WEST SUSSEX COUNTY COUNCIL CONSULTATION

TO:	Arun District Council FAO: Michael Eastham
FROM:	Highways, WSCC: Tim Townsend
DATE:	12th December 2018
LOCATION:	Kingsley Gate, Courtwick Lane, Littlehampton, BN17 7PE.
SUBJECT:	LU/283/18/DOC Approval of details reserved by condition imposed under LU/355/10/ relating to conditions 8-surface water drainage, 10-foul drainage, 12-tree protection scheme, 14-ecological enhancement & mitigation measures, 15-ecological management plan, 17-construction method statement, 18-construction compound details, 20-vehicle wheel cleaning facilities, 21-refuse & recycling bins, 22-bin lorry tracking, 23-car, motorcycle & bike parking & 29-schedule of materials & finishes.
DATE OF SITE VISIT:	
RECOMMENDATION:	☒ Advice ☐ Objection ☐ Modification ☐ No Objection ☐ More Information ☐ Refusal
S106 CONTRIBUTION TOTAL:	£N/A for this DOC application

This report specifically responds to conditions 17, 18, 20, 22 and 23. Conditions 8, 10, 12, 14, 15, 21 and 29 are matters for other specialist officers to reply to.

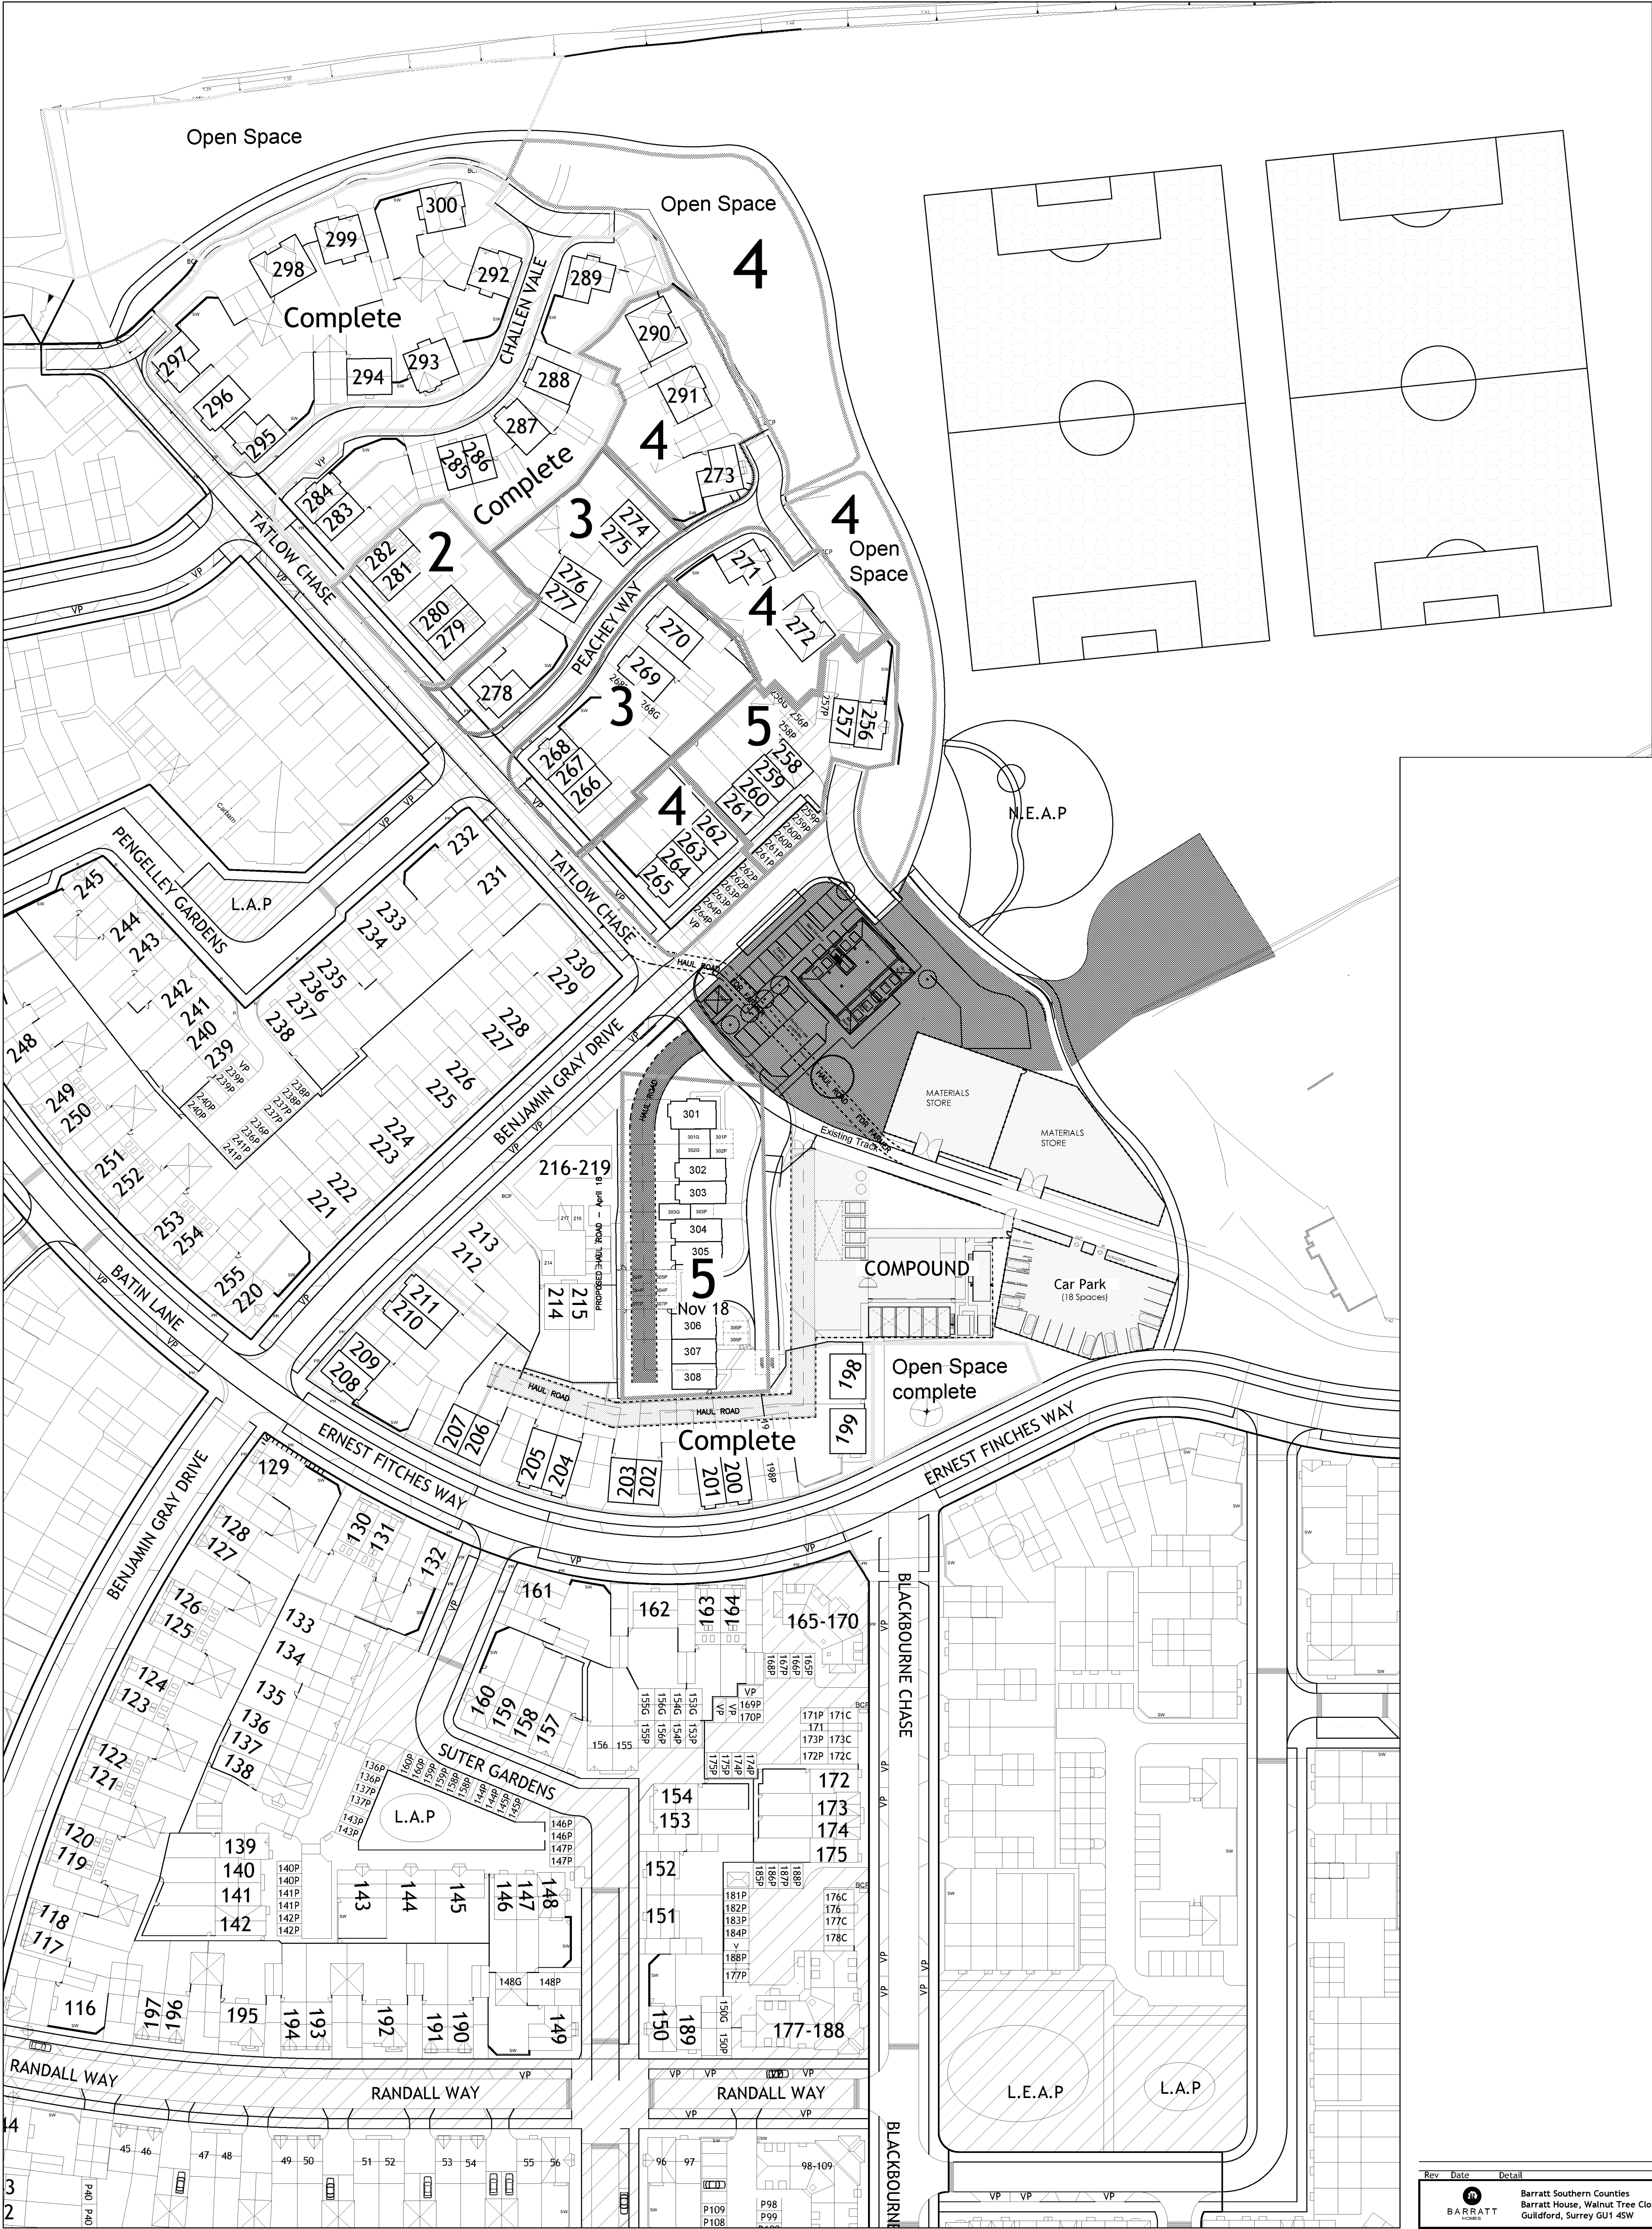
- Condition 17 (Construction Method Statement)** – *This is shown on plan BH744002PH02 (no revision). From a highways point of view, the applicant should ensure that construction vehicles follow the shortest and most direct route to the A259. Contractors must not use Courtwick Lane to reach the site. Also, it is recommended that contact details for the contractors – including out-of-hours and emergency contact details – be displayed prominently on site offices and boundary fencing throughout the construction period. The applicant should ensure that any rights of access along Old Courtwick Lane are maintained throughout the course of construction. In the event that this is not possible, it is then recommended that suitable alternative access be*

provided if the lane needs to be closed for safety reasons. LPA to comment on any non-highway aspects.

- 2. Condition 18 (Construction compound details)** – *This is shown on plan BH744002PH02 (no revision). LPA to comment also.*
- 3. Condition 20 (Wheel cleaning facilities)** – *This is documented in letter of 27th September 2018 (Barratt Homes – Darren Kenny to Michael Eastham). It is recommended that in addition to wheel washing that there is at least one daily sweep of the roads and more if considered necessary.*

Drawing Number	4485/257			Rev.						
				M

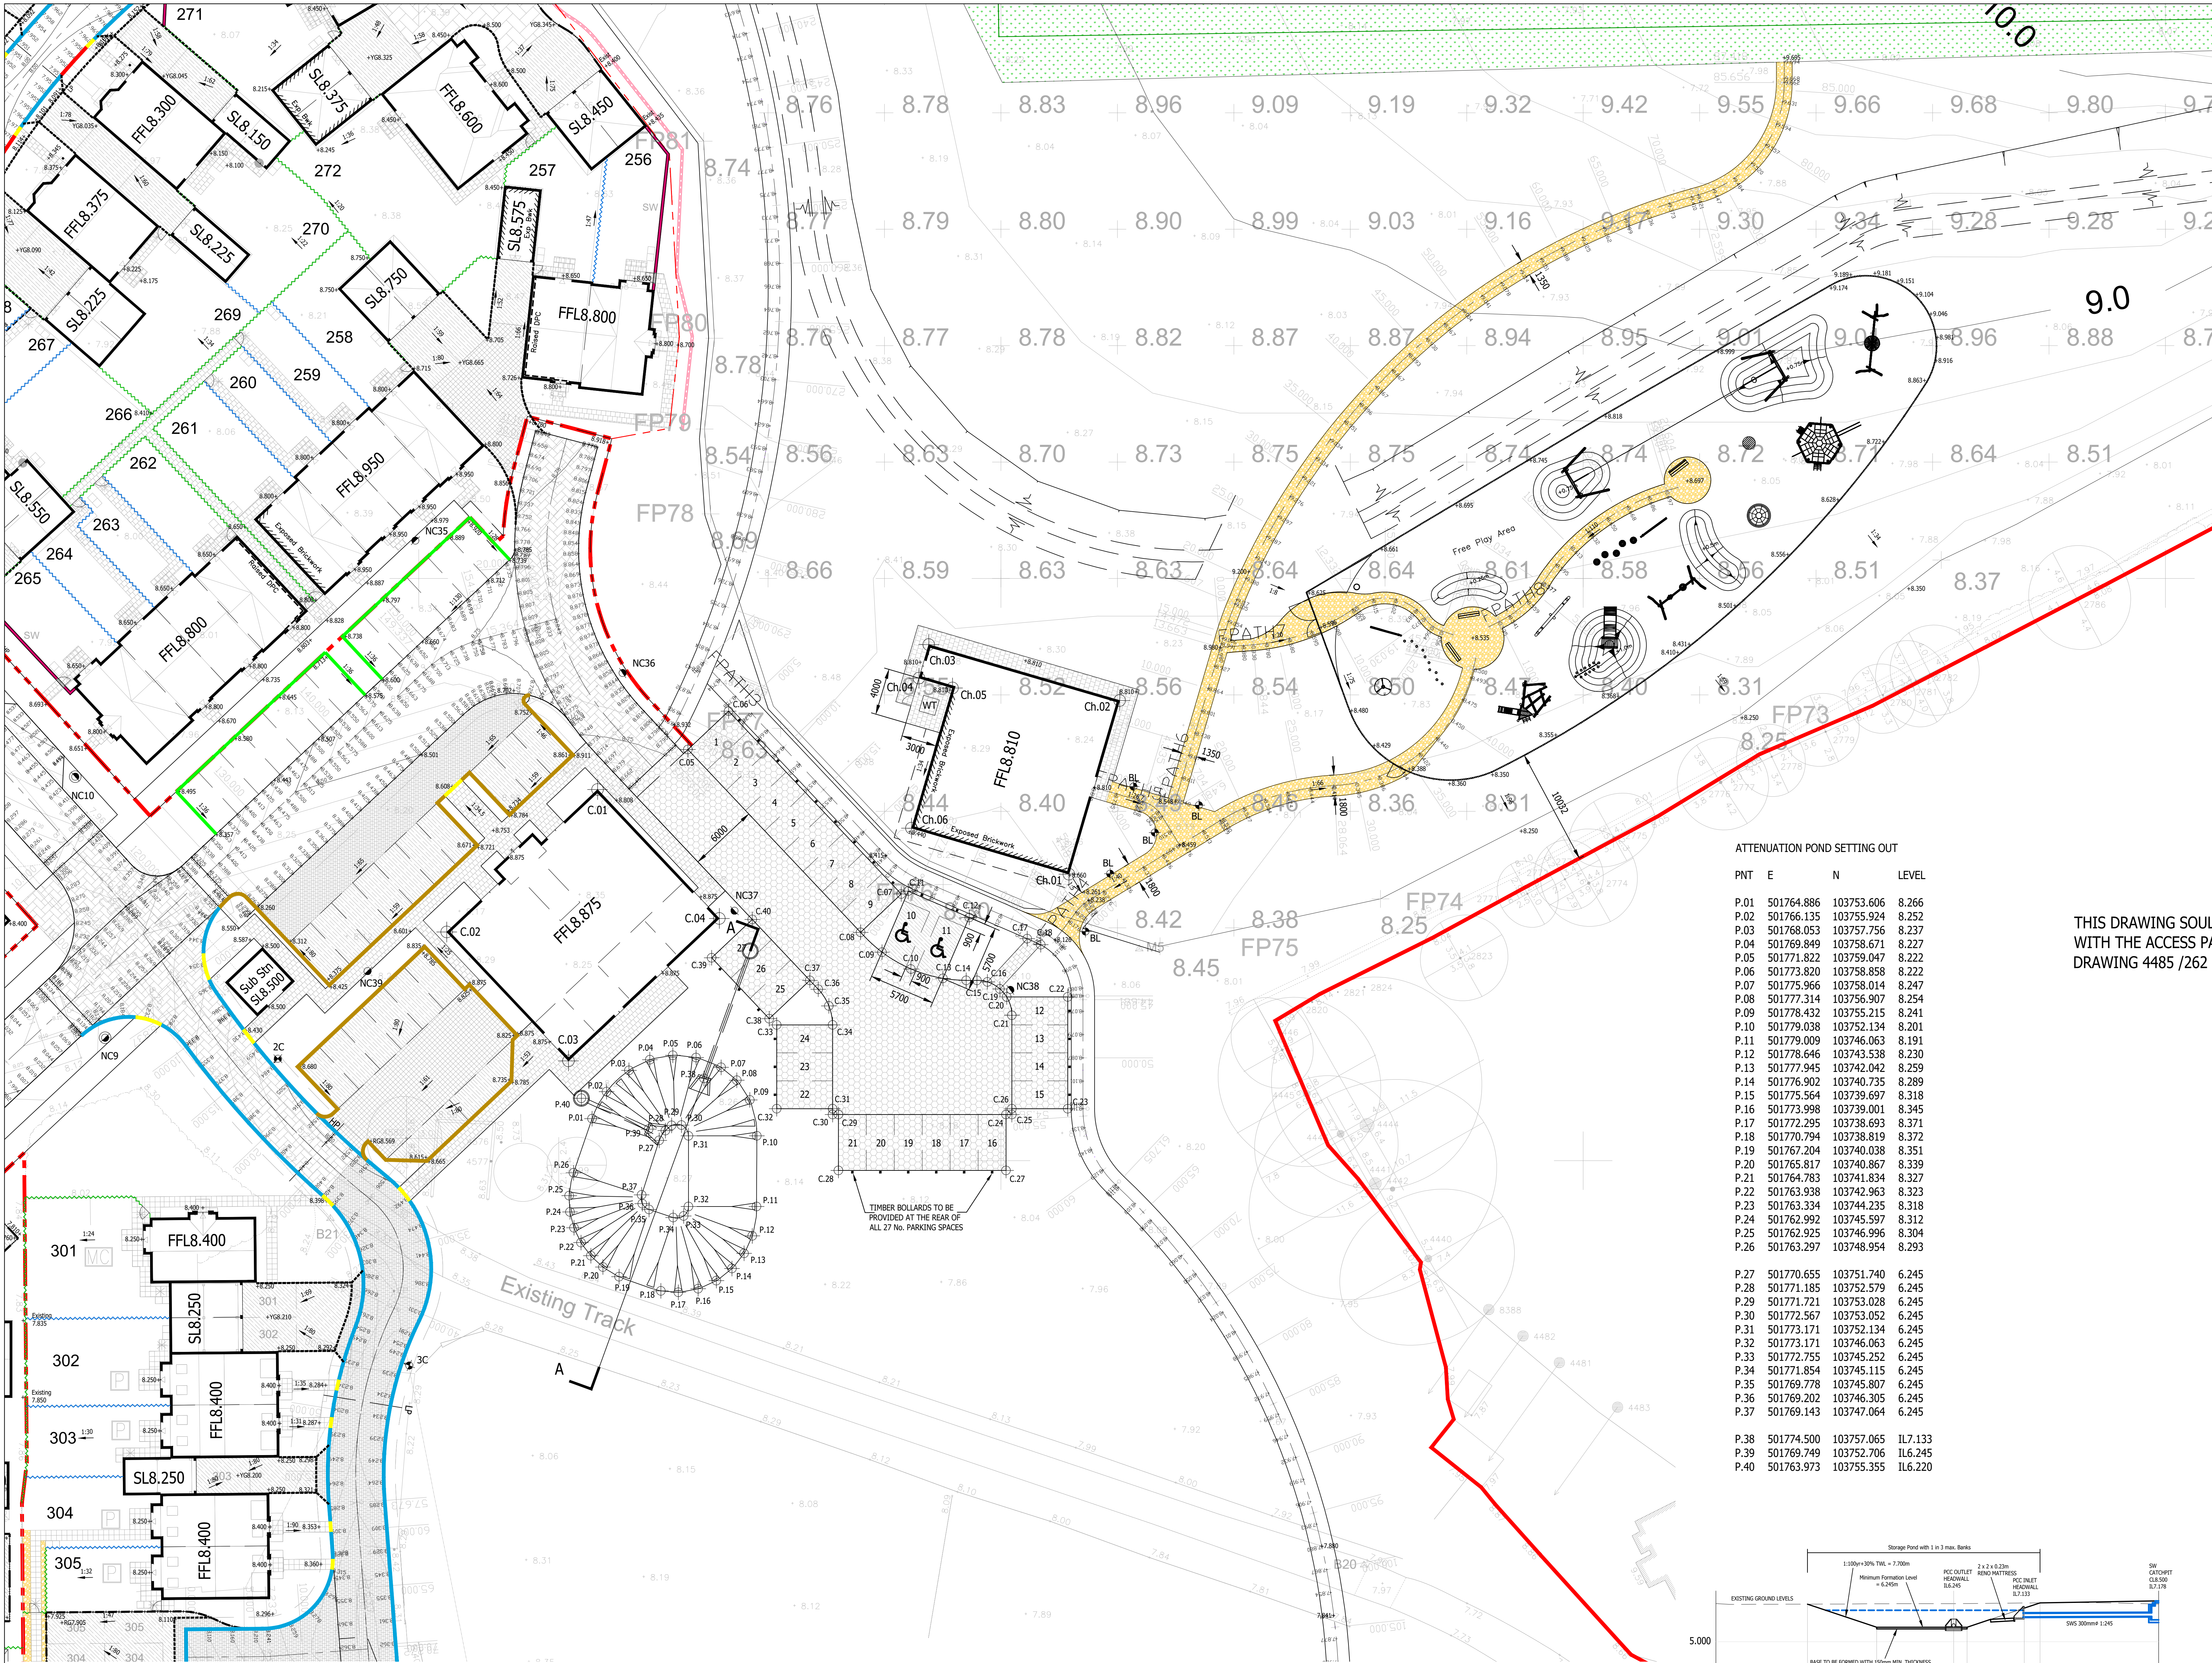
As shown on the submitted drawings, 18 Spaces are shown alongside the mixed use building with an additional 2 spaces shown to the north-east of it. A further area of land (laid-out to what appears to be a turning head – also east of the commercial building) appears to offer a further 5 'informal' spaces (i.e. not marked-out). It is not known how these would be distributed between the different uses. In addition to this, the outline proposals showed a Grasscrete (or similar material) area for up to 20 cars to park on match days. This would also provide a flexible parking area for the A3 use if needed. WSCC is unable to determine whether this is still offered nor whether it would be an appropriate number as it is unclear how many pitches there will be. Although car sharing is often common practice or the use of mini buses for these types of activities would reduce the number of vehicles entering and exiting the site. How this informal area is used would either have to be secured by planning condition and/or managed by the owner, Management Company or operator/user(s) of the facilities.
